**National
Trust**

**Application by Equinor for an Order Granting Development Consent for the
Sheringham and Dudgeon Extension Project (EN010109)**

Procedural Deadline 1 Submission: Written Representation

Figure 3: Phase 1 Habitat Survey Results Map 1 (Weybourne Woods to Landfall)

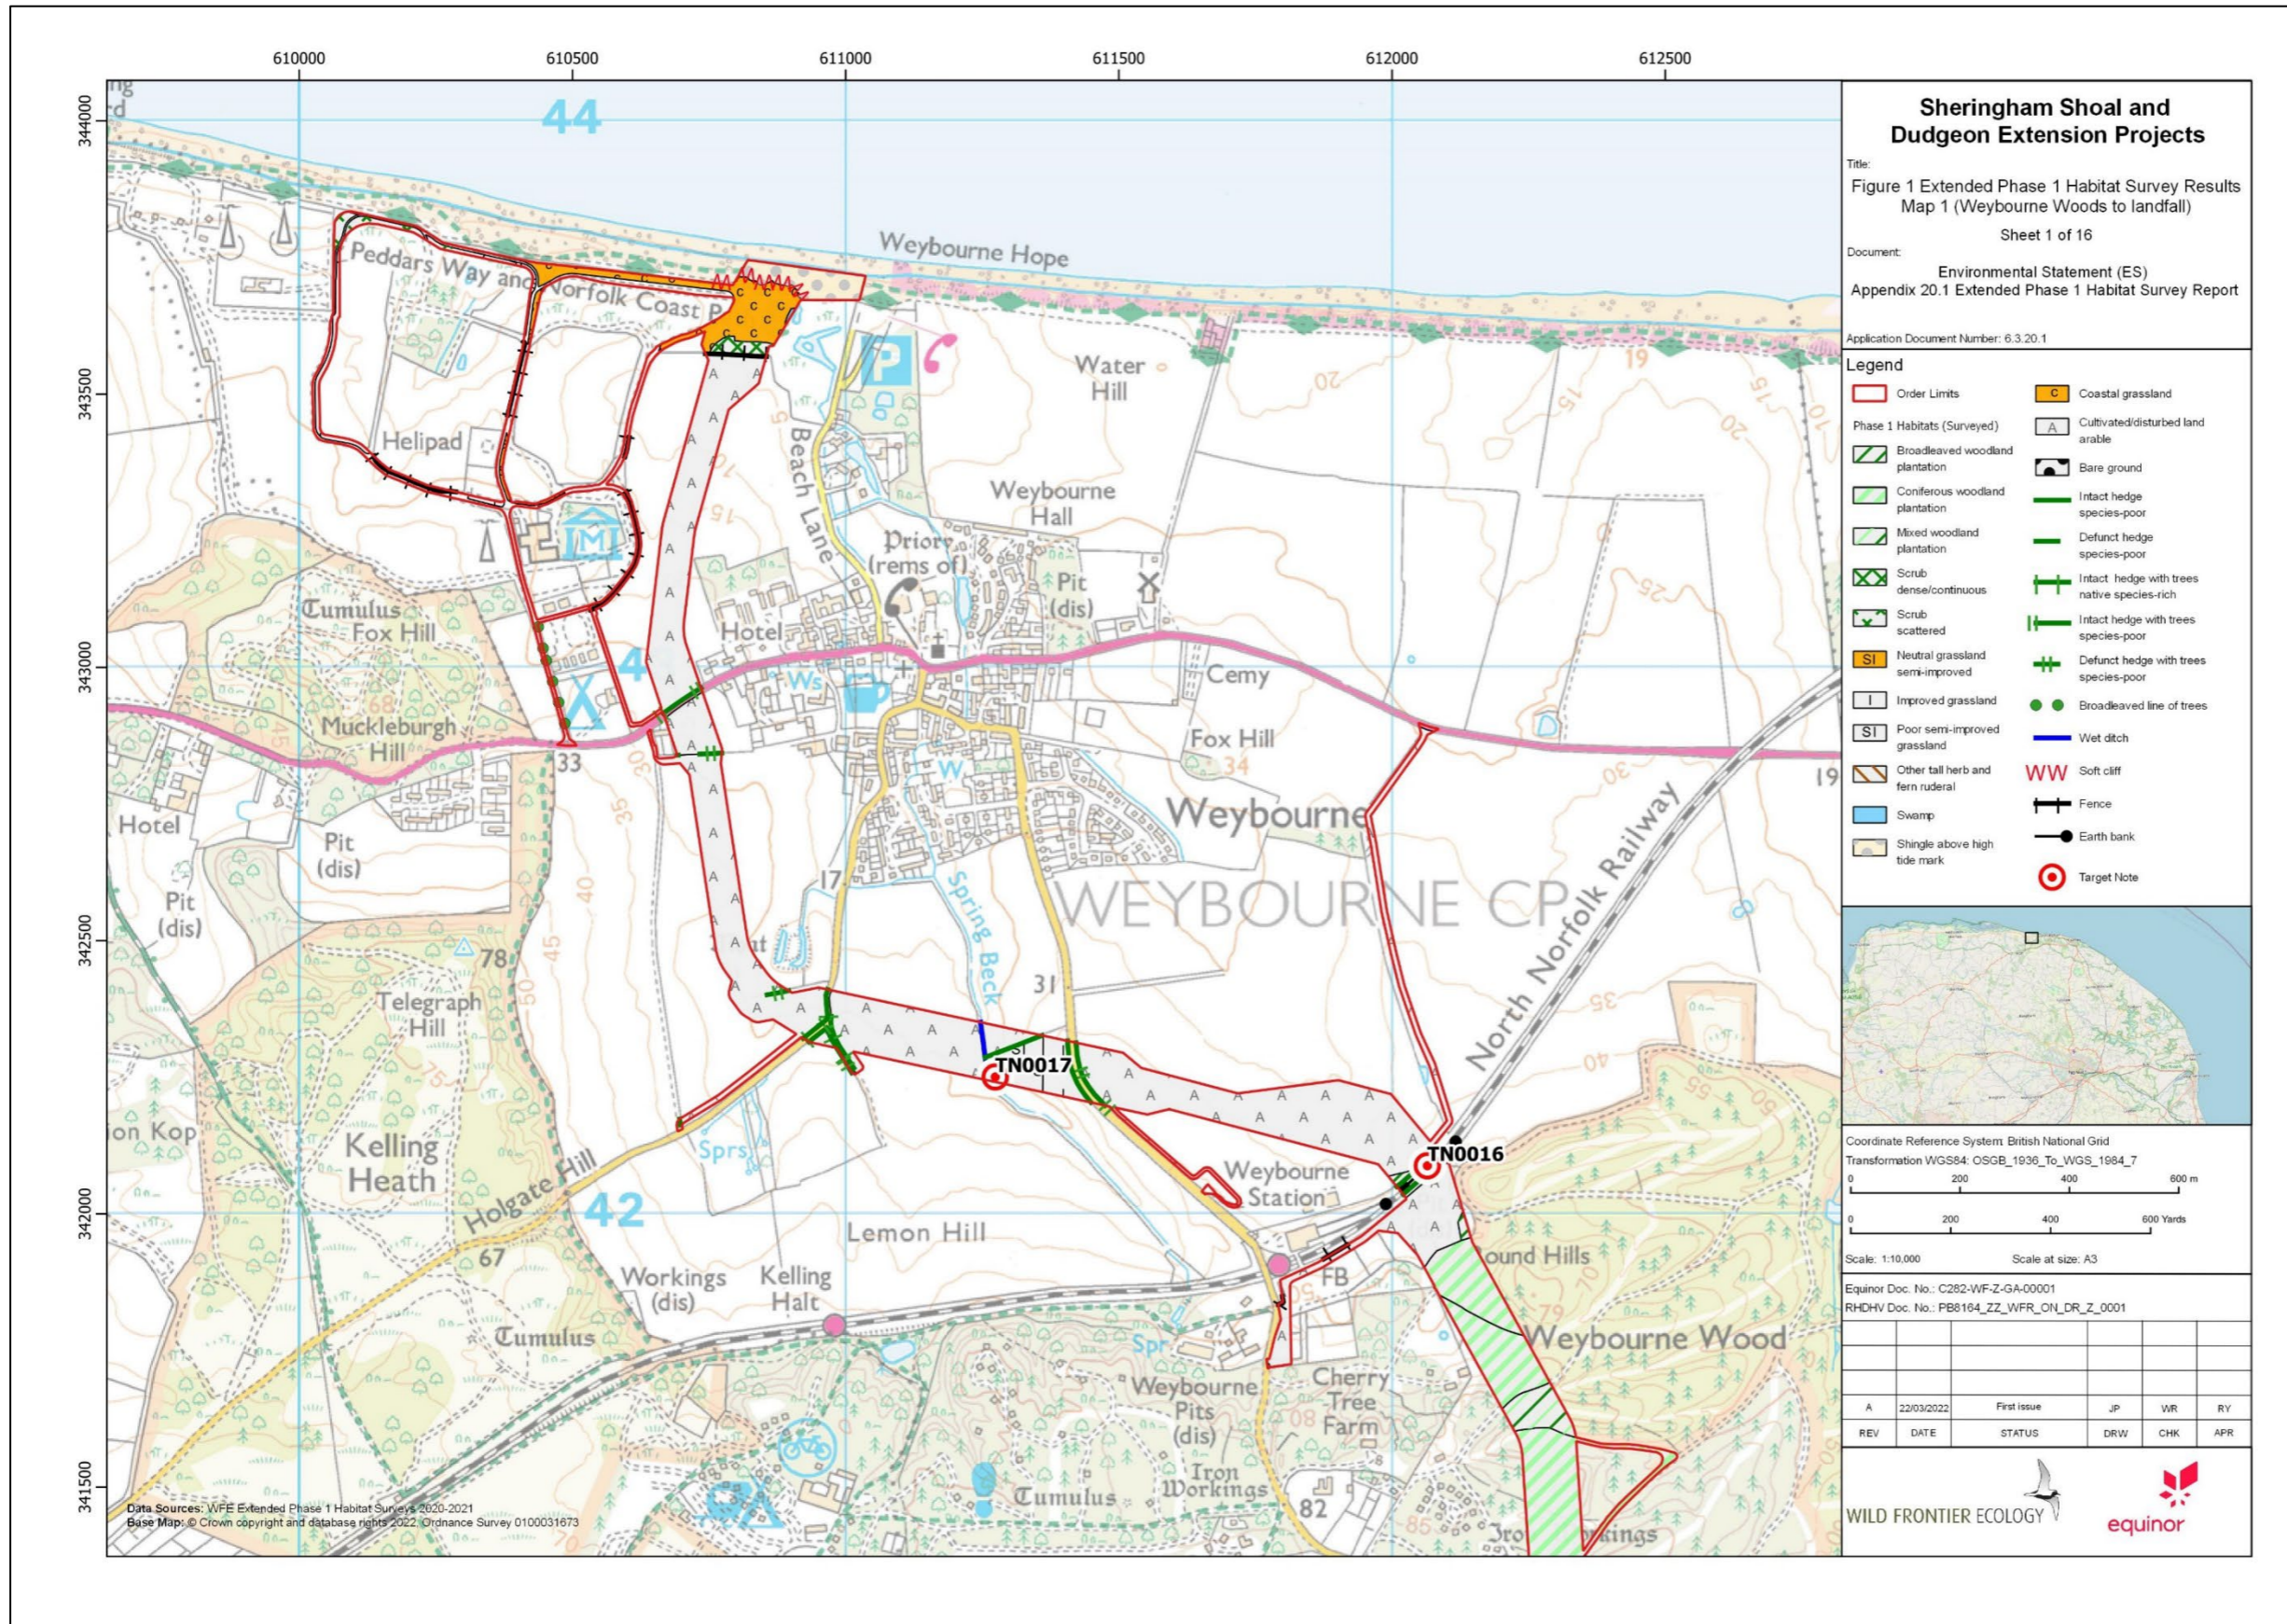
Weybourne Woods was declared inalienable in order to protect views from Sheringham Park and prevent inappropriate development. Construction impacts on Weybourne Woods and the AONB have been identified as moderate significance and adverse impact in the submitted Landscape and Visual Impact Assessment (Examination Document Ref: APP-112). Furthermore, it is proposed to remove an area of forestry at the HDD launch and reception pit.

Since submitting our Relevant Representation, the National Trust has met with the developer to discuss this issue. It is understood that replacement trees will not be proposed along the cable route or in the location of the reception pit. It is understood that at this stage only baseline habitat surveys have been undertaken. The developer has advised the Trust that pre-construction surveys would be carried out and these would inform the proposed landscape, arboricultural and ecological mitigation and enhancements. In order to adequately address our concerns, the Trust therefore wishes to be named as a consultee in the 'Outline Landscape Management Plan' and 'Outline Ecological Management Plan' and requests that the applicant updates these documents accordingly.
